Appendix B – Submissions Response Table (SSD- 65924461)

Bayside Council		
Council has reviewed the submitted documentation and raises several objections, below. These objections are predominantly due to a level of missing or incomplete information to demonstrate how the proposal in its current form is suitable for the site and within the locality, and how some site-specific environmental issues will be managed. It is requested that the Applicant provides additional information to address Council's concerns.	Noted. See below.	N/A
Built Form		
<u>1. Site Analysis / Context</u> A detailed analysis has been provided to outline the primary constraints and opportunities of the site, establish fundamental principles for the development and explore several design options for the site. However, the architectural drawings still lack context as the proposed building is largely shown in isolation, and no elevation or section has been provided to show how the proposal relates to the low-density residential context of Stephen Road. A clear and accurate depiction of how the proposal relates to the low-density residential context of Stephen Road has not been provided.	An updated set of Architectu

3 SHADOW DIAGRAM - SUMMER SOLSTICE - 3pm 1 : 1500

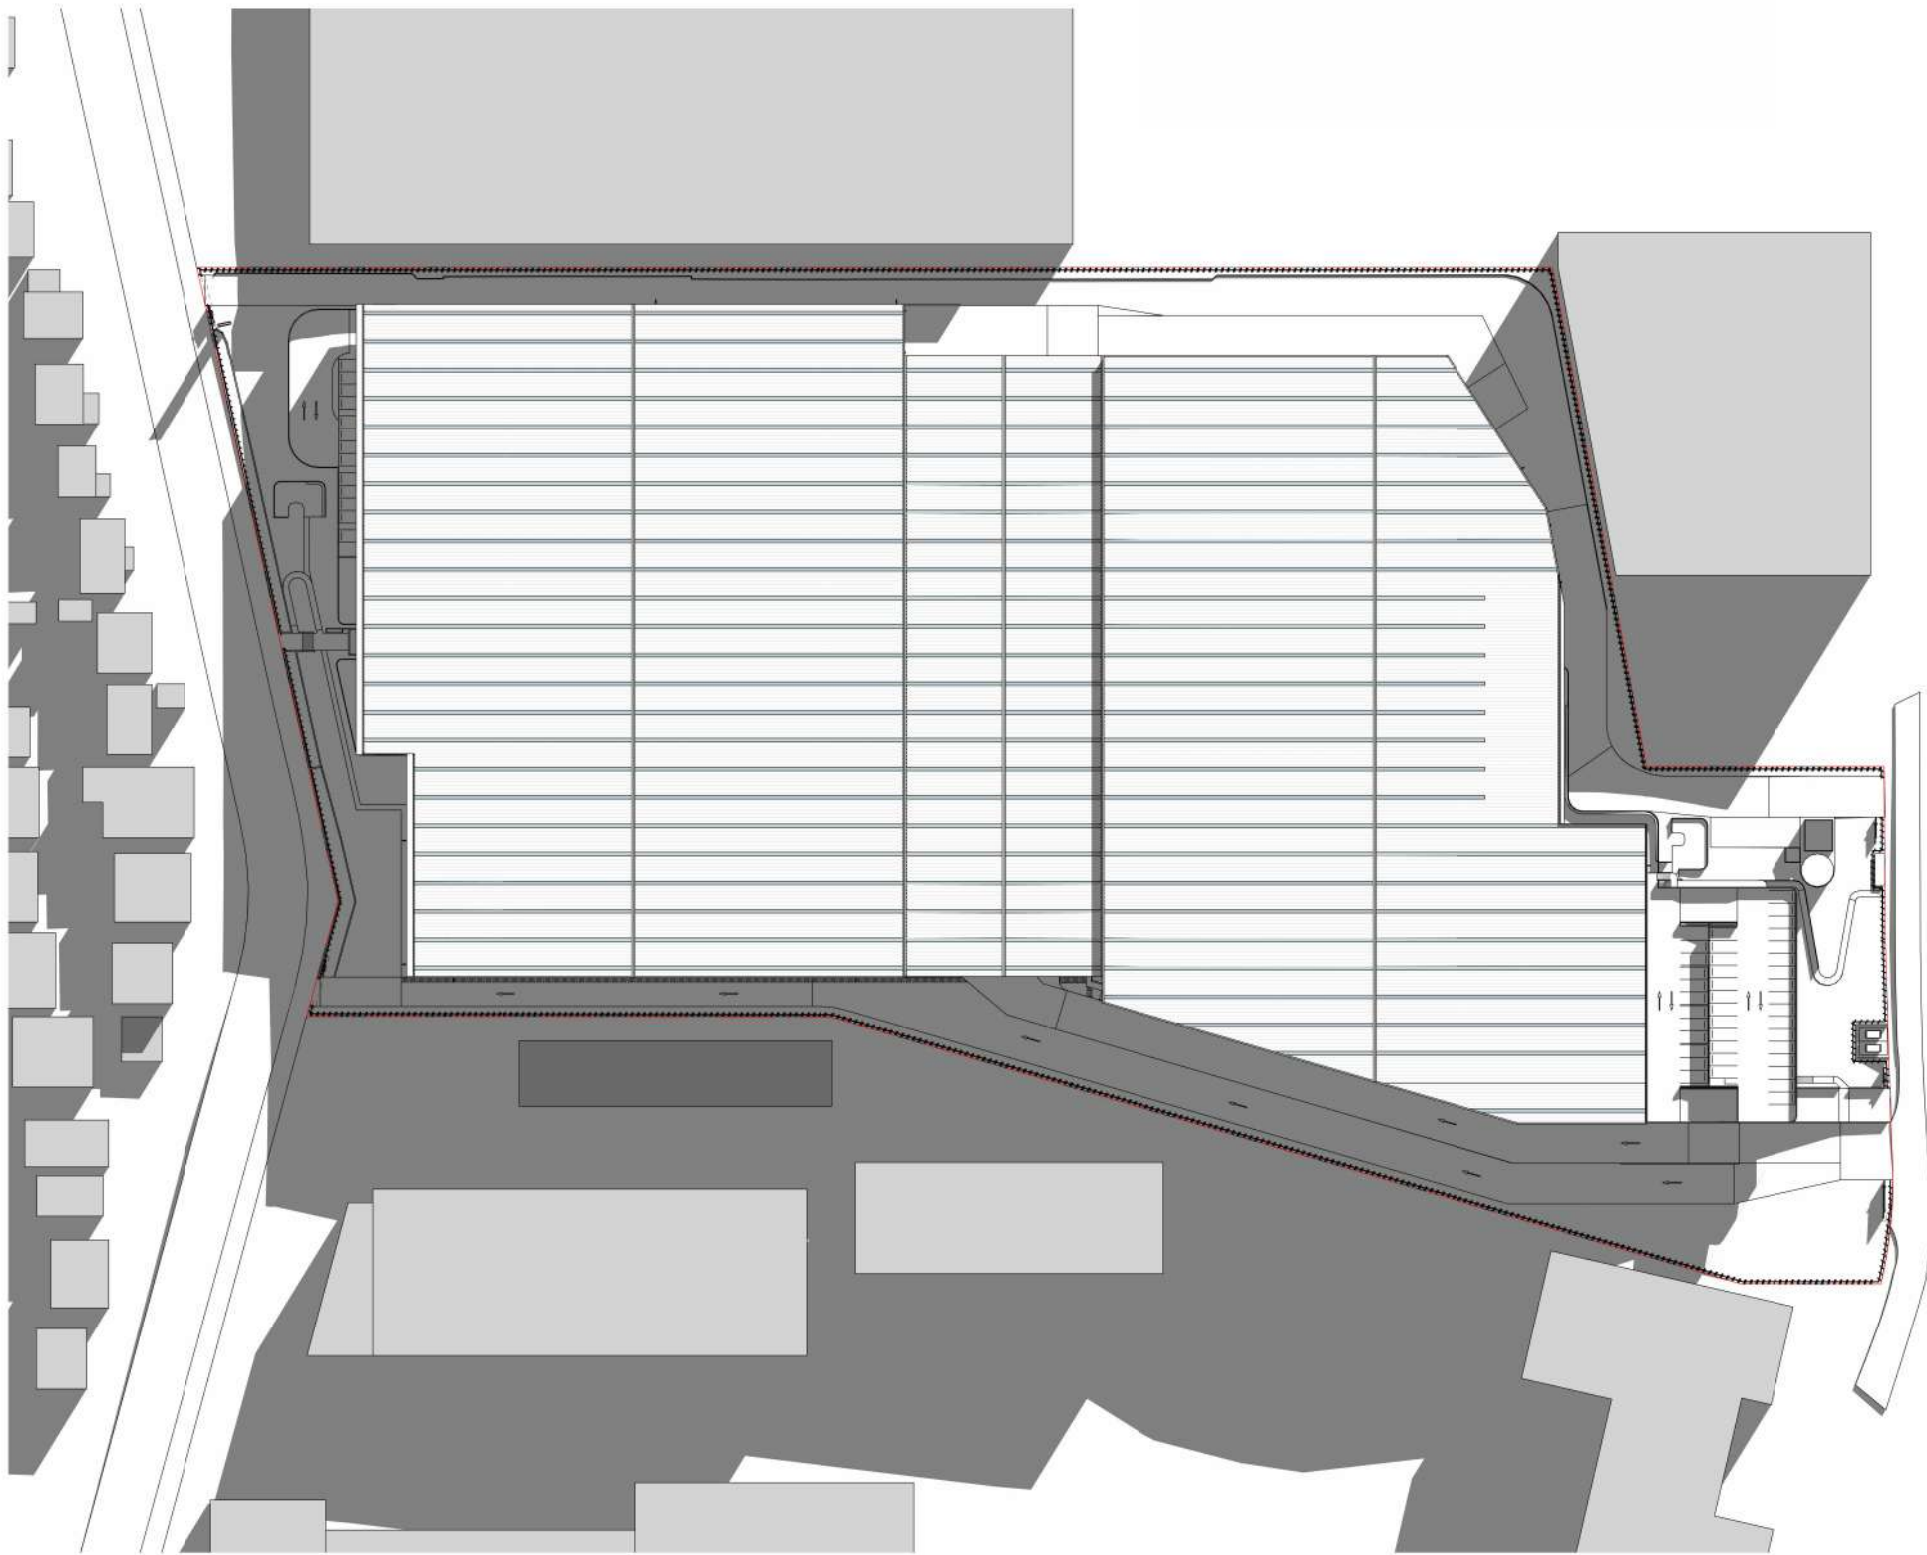
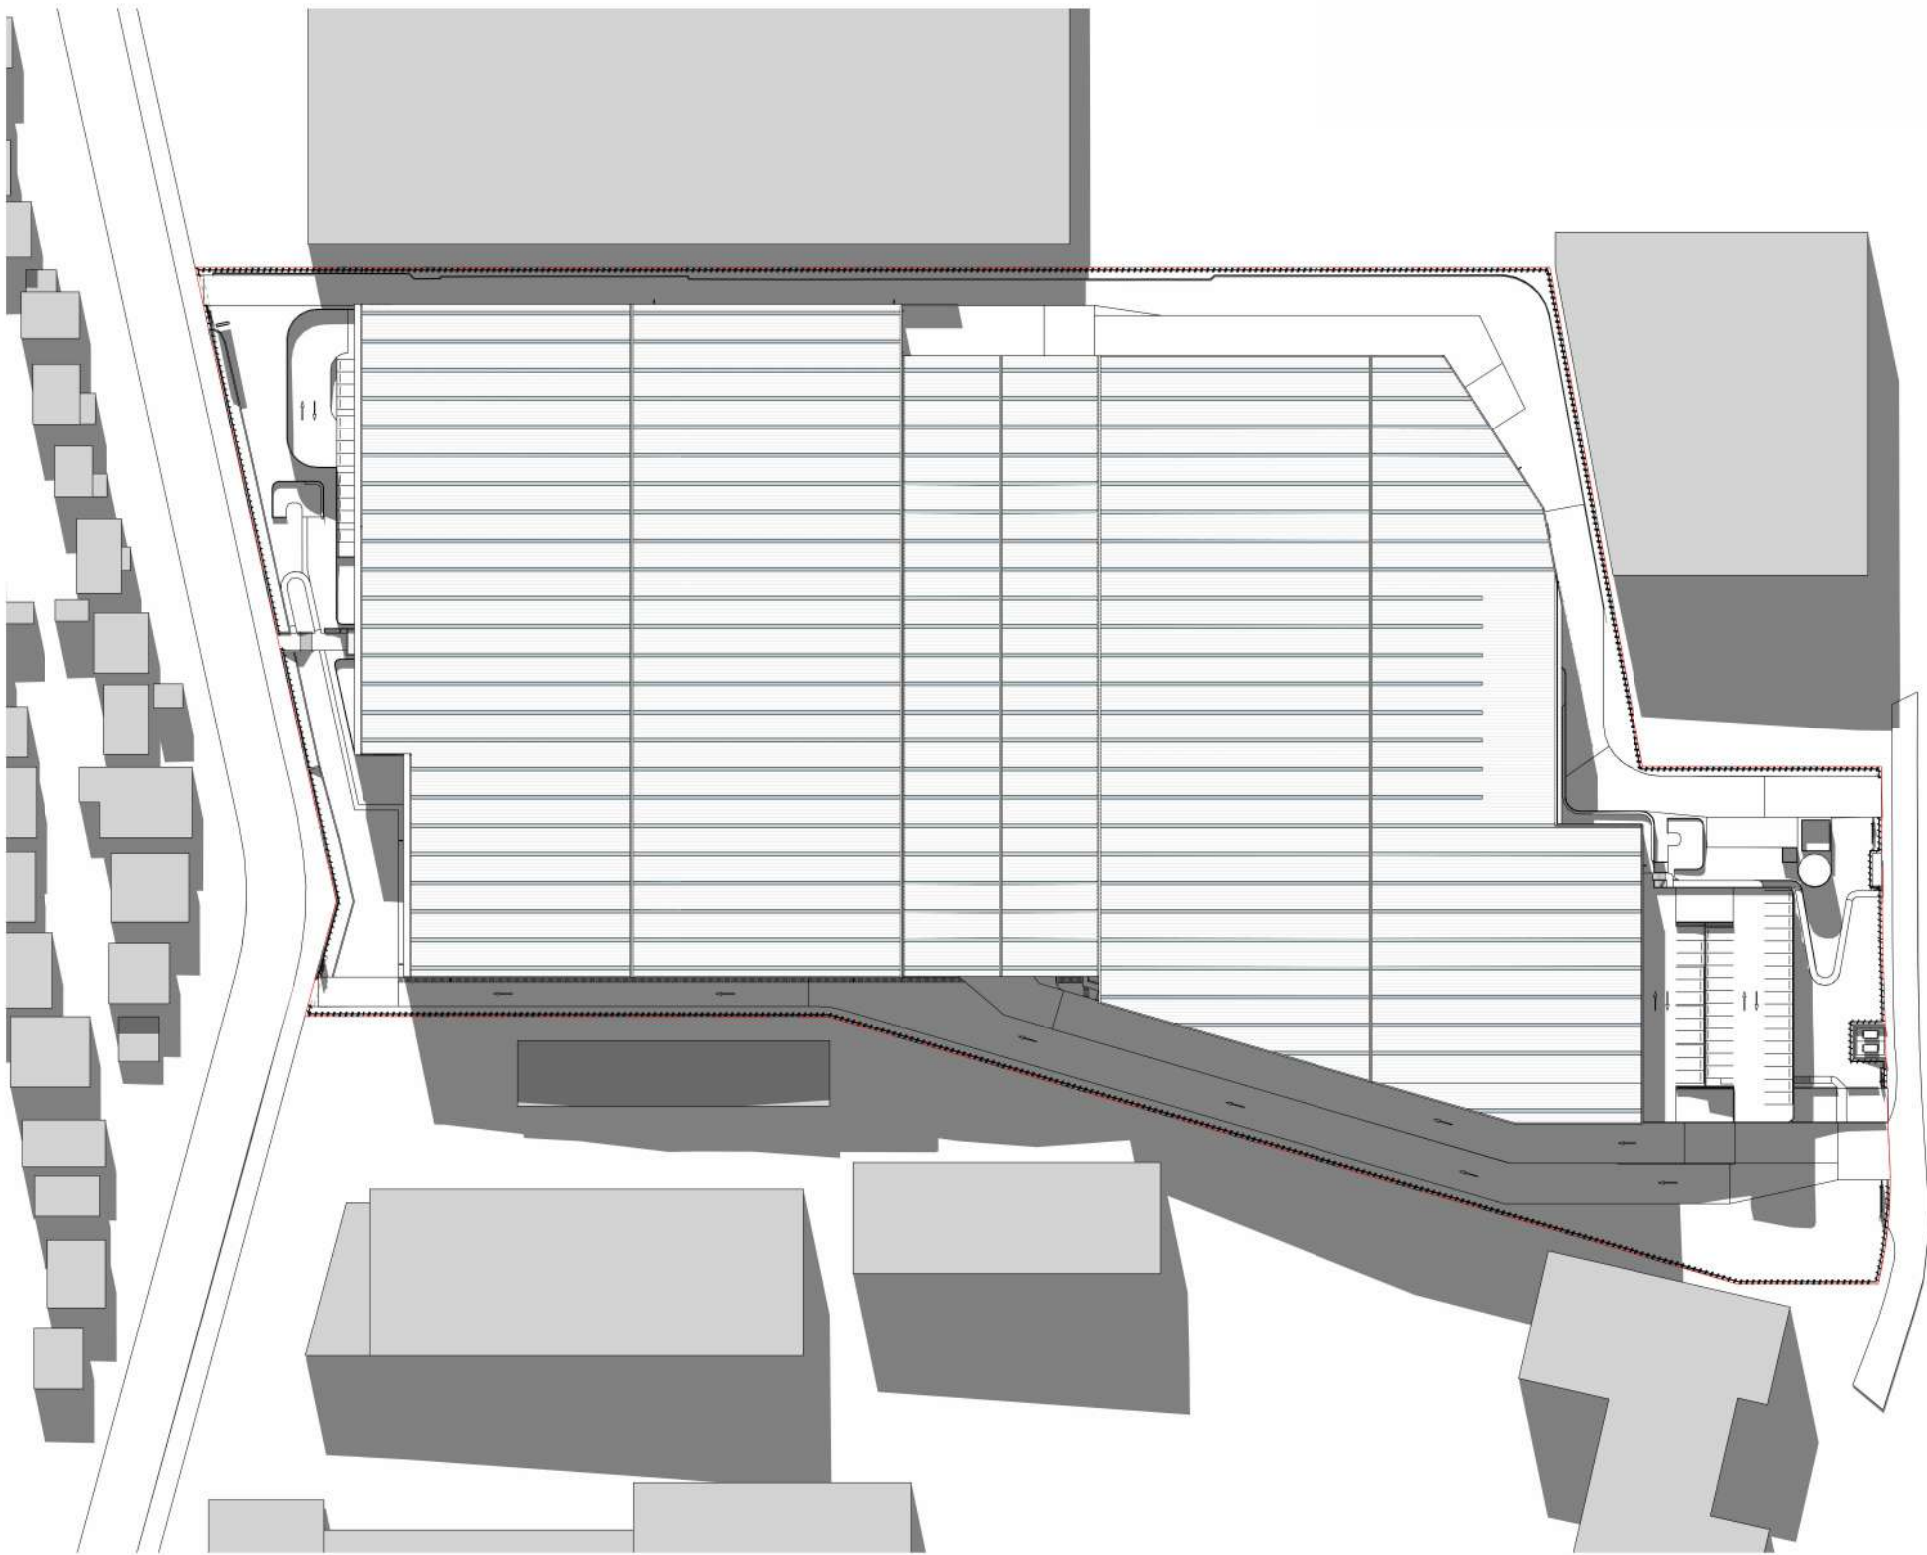
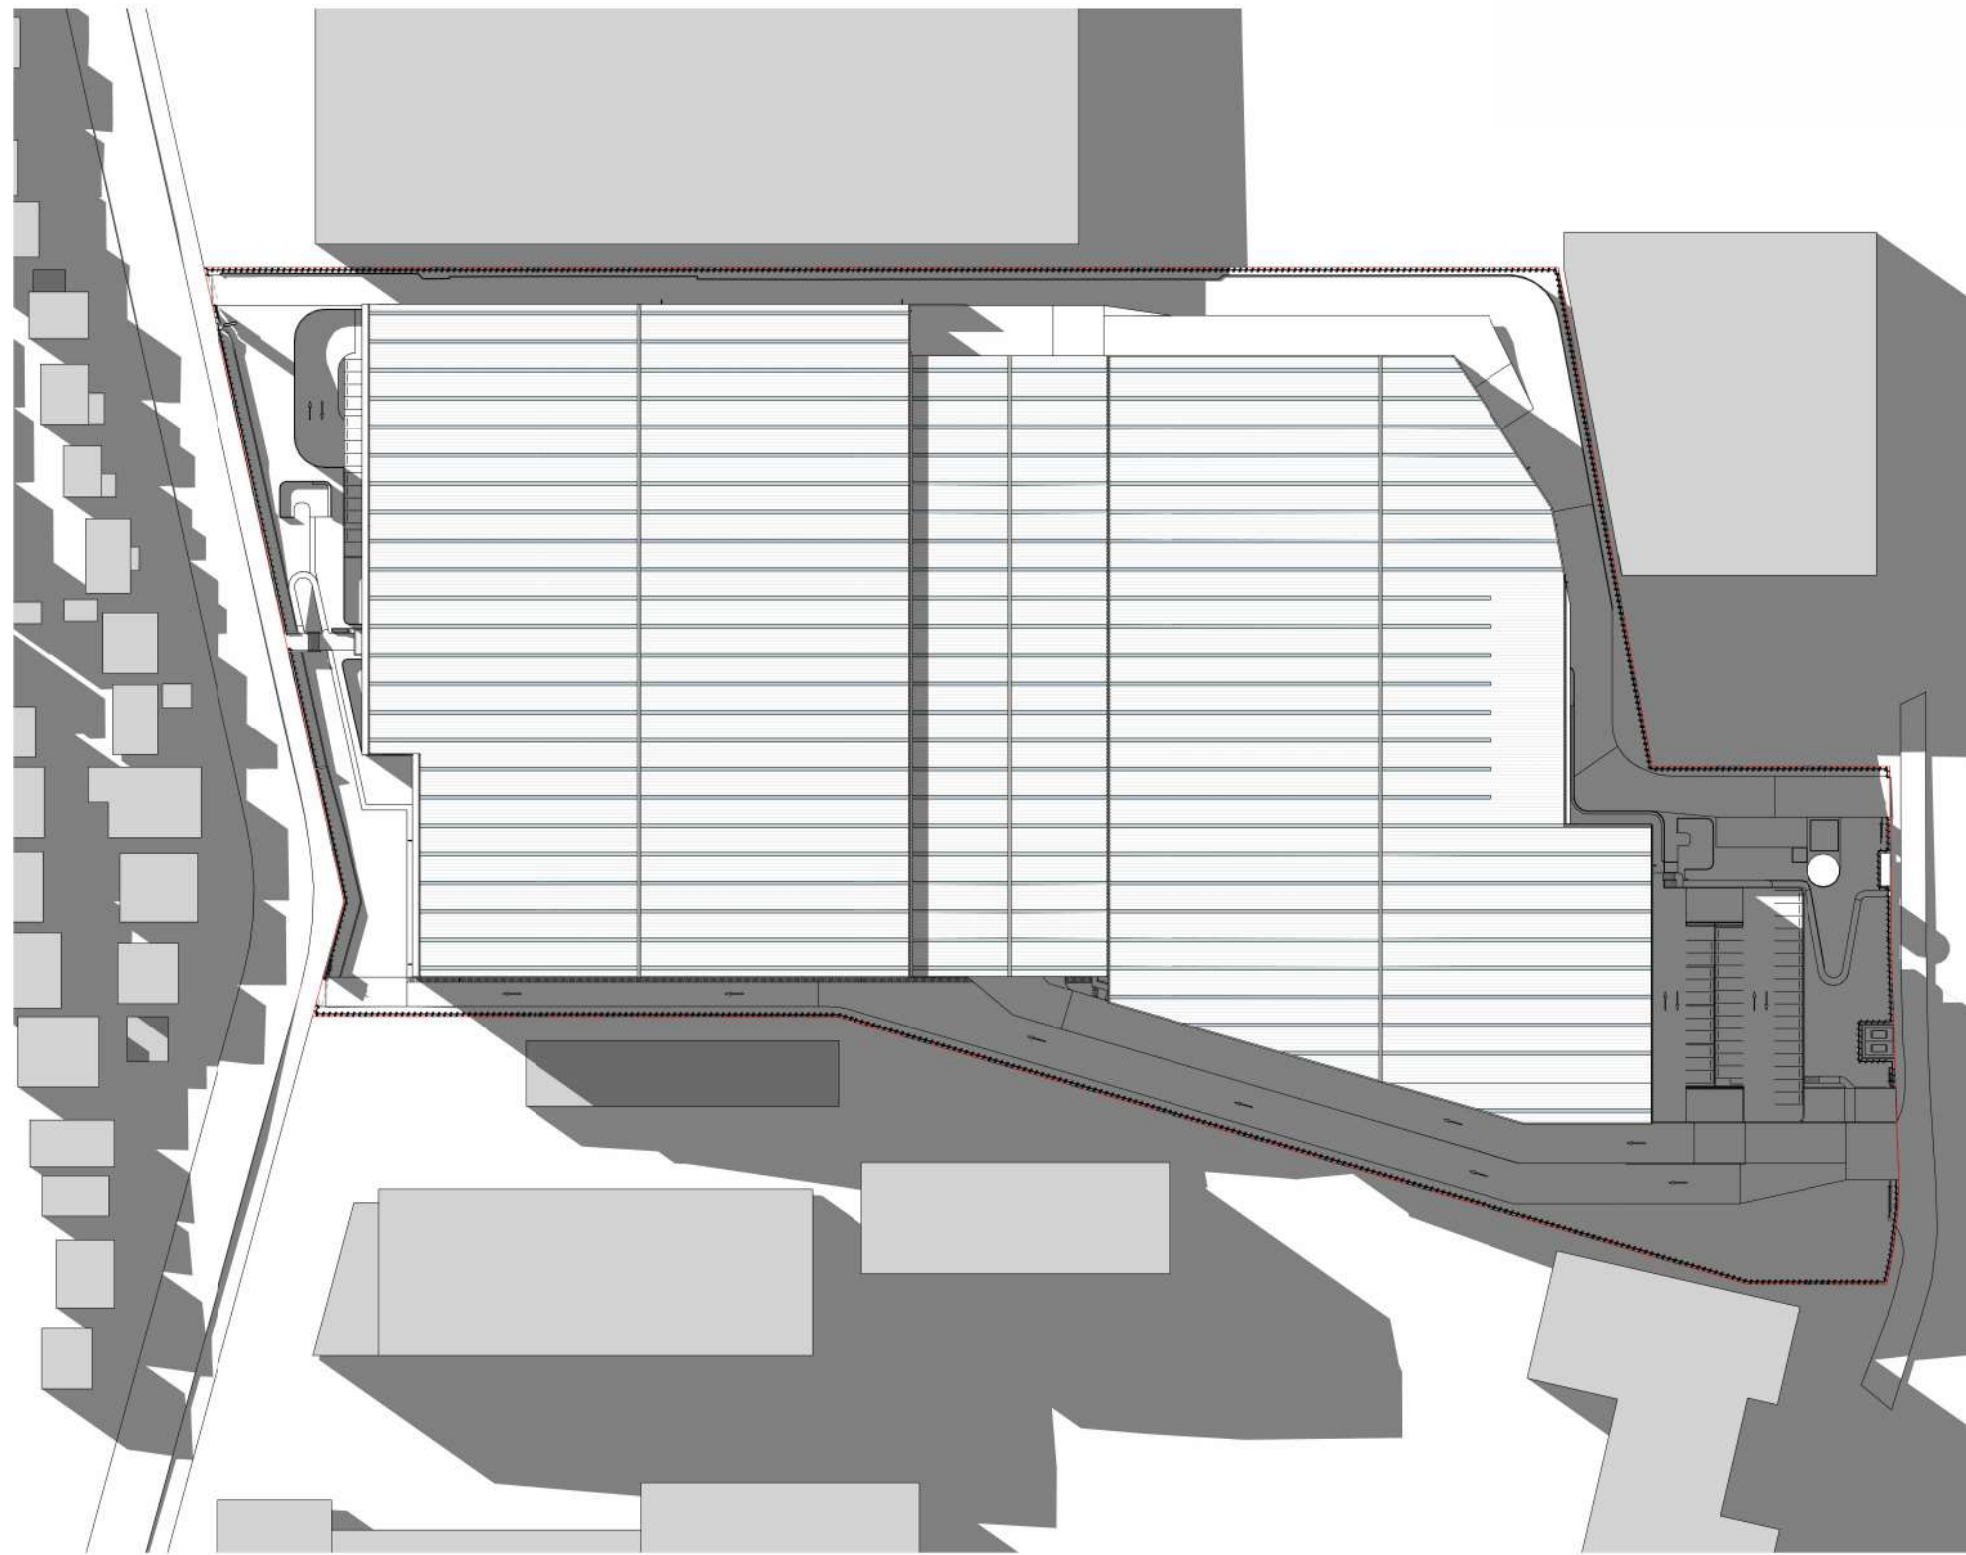
4. The Department raises concerns over the shadowing impact the proposal will have on residential properties opposite the site on Stephen Road, particularly during winter mornings. Revising the buildings interface with Stephen Road by reducing the scale of the building will likely assist in minimising the impact on solar access to the sensitive receivers.	Further to the above, updated shadow diagrams provided in the revised Design Report demonstrate that the two-storey scheme results in significantly less overshadowing than the previous design. The reduced height, increased setback, and larger landscaped buffer along the Stephen Road frontage work together to improve solar access to dwellings opposite the site. The revised footprint also limits the amount of warehouse floor space positioned directly along the boundary, further minimising bulk and shadow impacts.	Appendix F Appendix I

4. <u>Solar Analysis</u> A review of the solar analysis and shadow diagrams provided in the Design Report, prepared by SBA (dated 18 November 2024), appears to show some discrepancies in depicting the extent of shadow cast over Stephen Road. The section in Figure 2 shows the shadow cast at 10AM, mid-winter as being approximately 49.6 metres in length. This is approximately 10 metres longer than the shadow shown on Page 30 of the Design Report (Figure 3). It is also noted that the position of residential dwellings depicted on shadow diagrams are not included in the survey drawing provided. Further information is required to clearly and accurately demonstrate the extent of overshadowing to existing residential dwelling on the western side of Stephen Road.	The revised two-storey design results in significantly less overshadowing impacts than the previous three-storey design. There will be no overshadowing of any dwellings, with a minor intrusion into the private open space along Stephen Road at 9amm which is considered a minor solar impact. New shadow diagrams have been provided in the updated Design Report at Appendix I.	Appendix I
